## COMMUNITY DEVELOPMENT DEPARTMENT

FILE #: PRE-APP PM-21-00003

RE: Proposed Bull Ranches Subdivision Project

LOCATION: Kittitas Hwy & Bull Road

STEVE LATHROP
THE BULL RANCH
 PRELIMINARY SITE PLAN
 KITTITAS COUNTY WASHINGTON

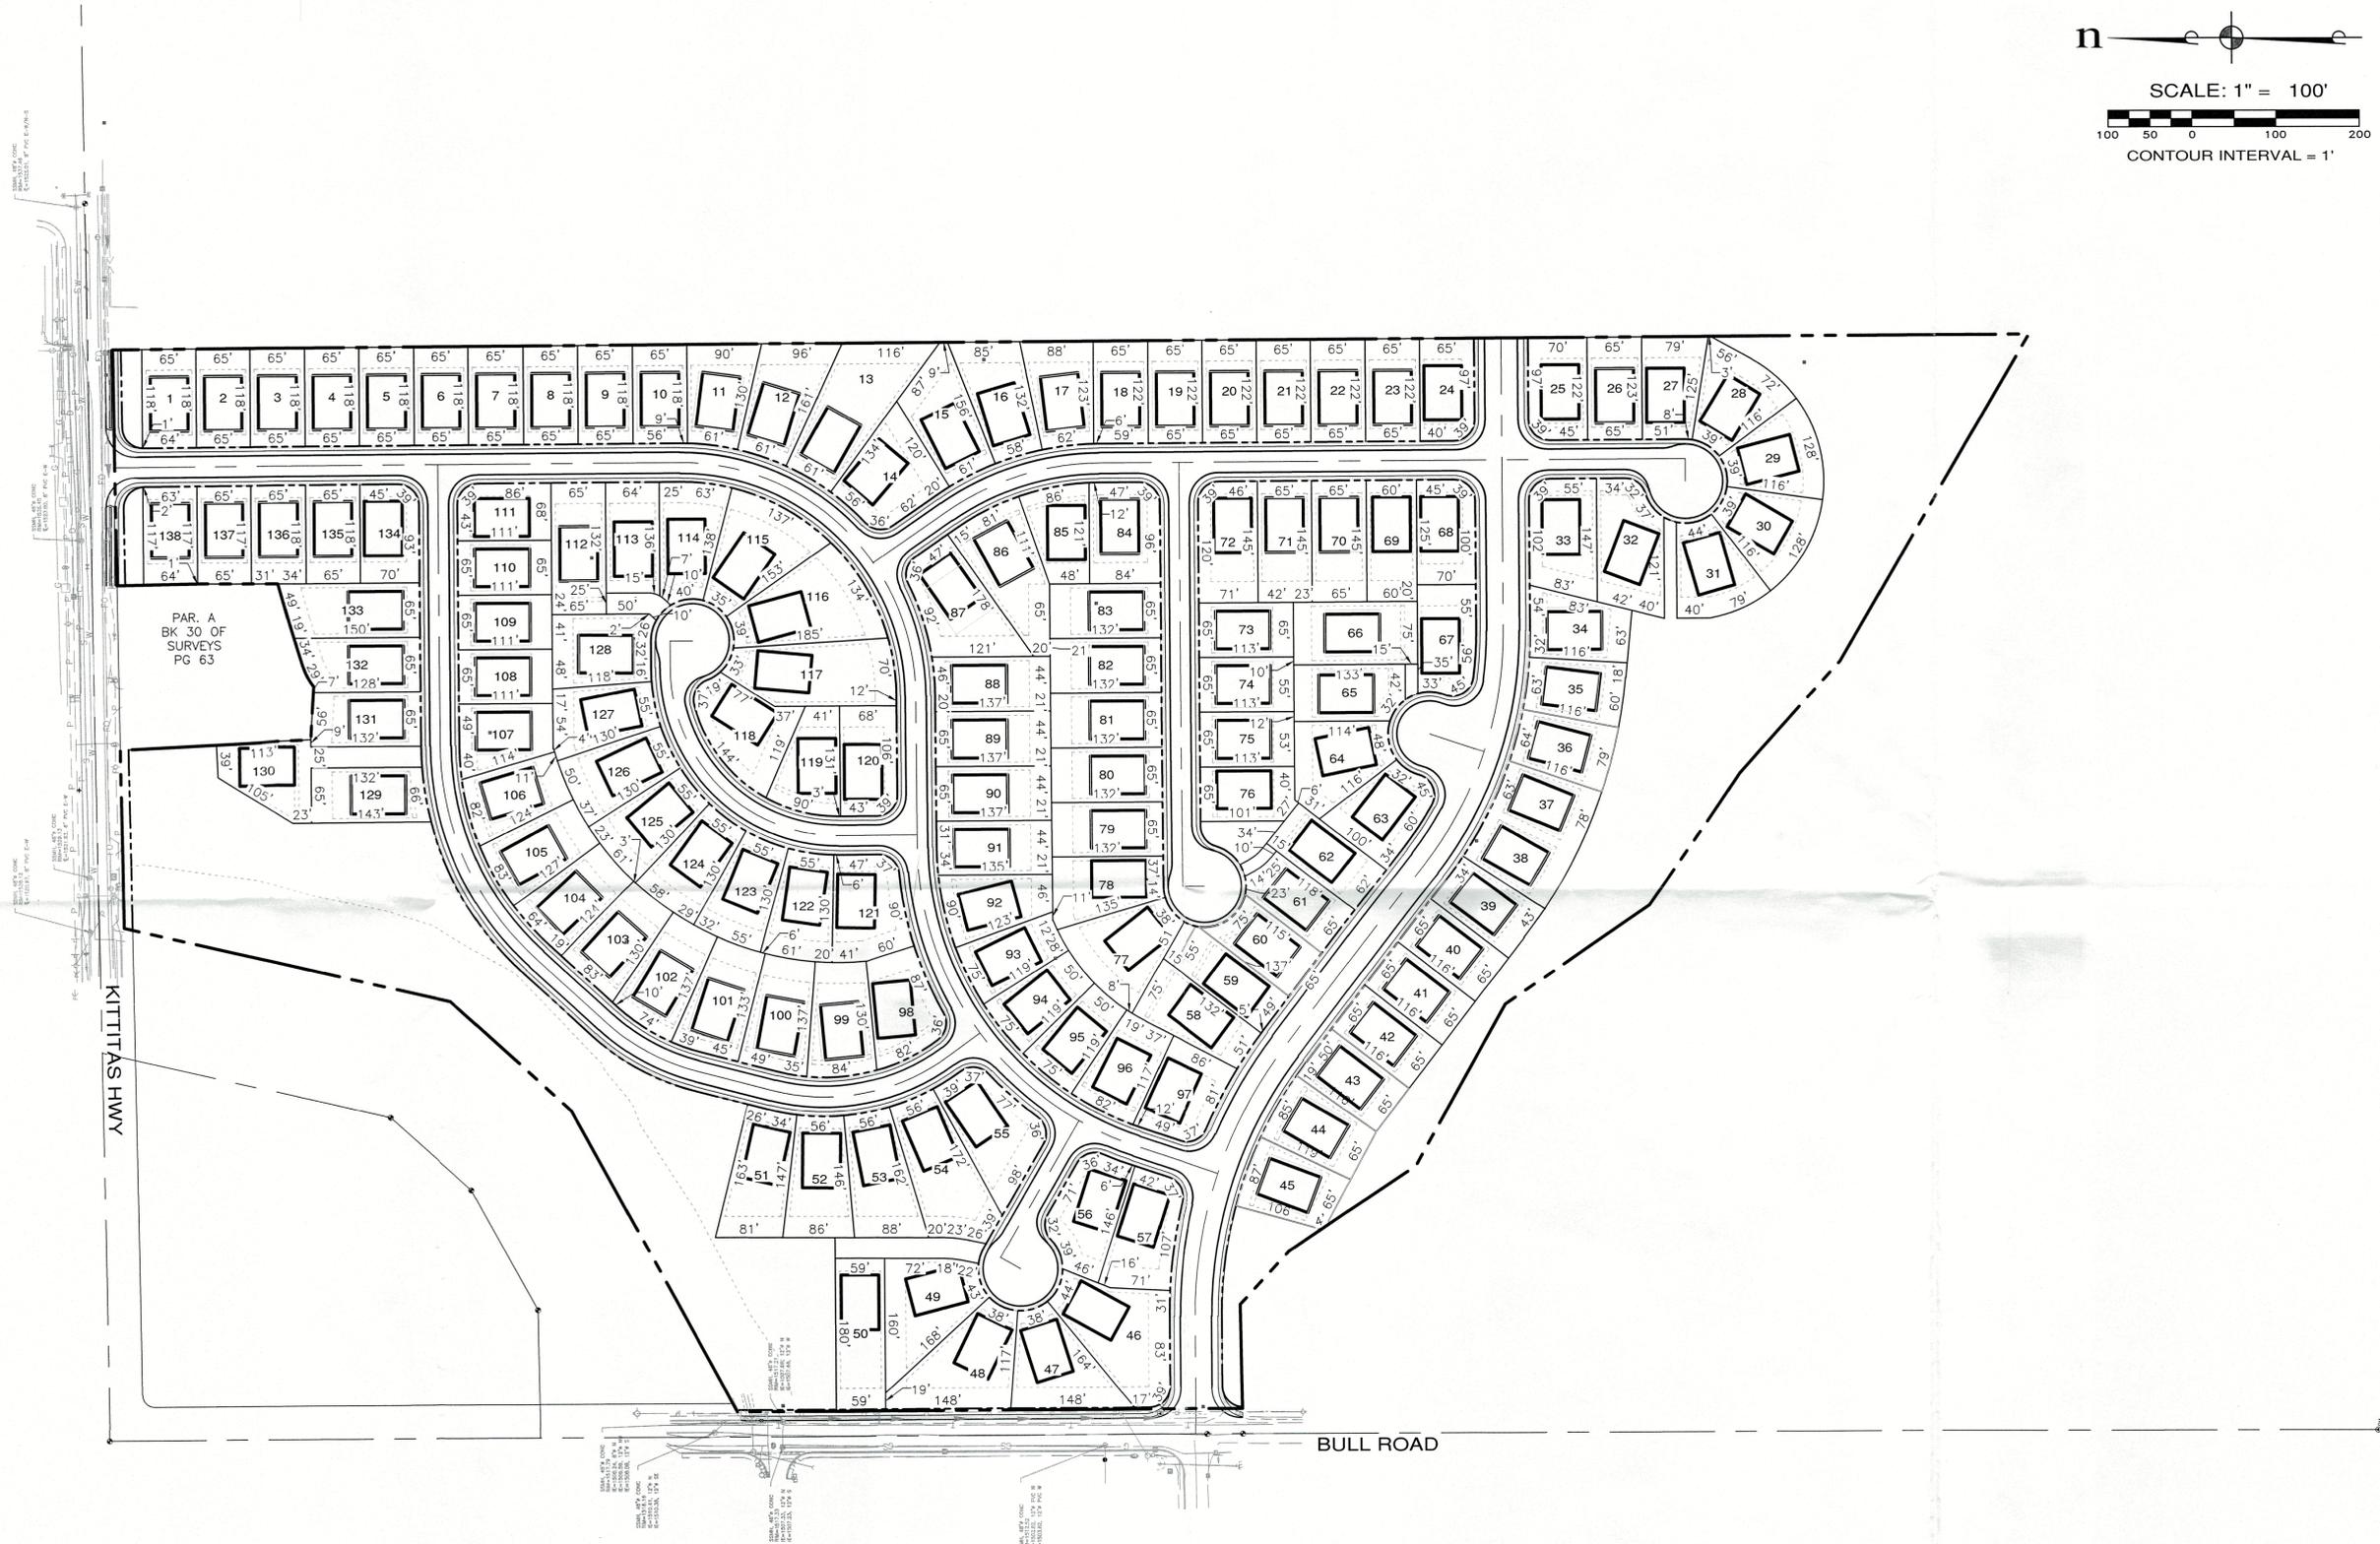
The City encourages you to plan this project to meet the development requirements of the Residential-Suburban (R-S) Zone as follows:

**Maximum Base Density for R-S Zone** = 6 dwelling units per acre (The Kittitas County Assessor's parcel information shows the parcel to be 45.02 acres, therefore the proposed 138 dwelling units is allowed)

**Minimum Front Yard** = 15 feet

**Minimum Garage Front yard** = 22 feet

**Minimum Rear Yard** = 20 feet

**Minimum Side Yards** = 5,10 feet

**Open Space Required = 10% of lot size – please see ECC 15.540.020 (E) for more details**

Lyle creek meanders through this site on the western property boundary and has a 50 foot stream buffer which will need to be considered.
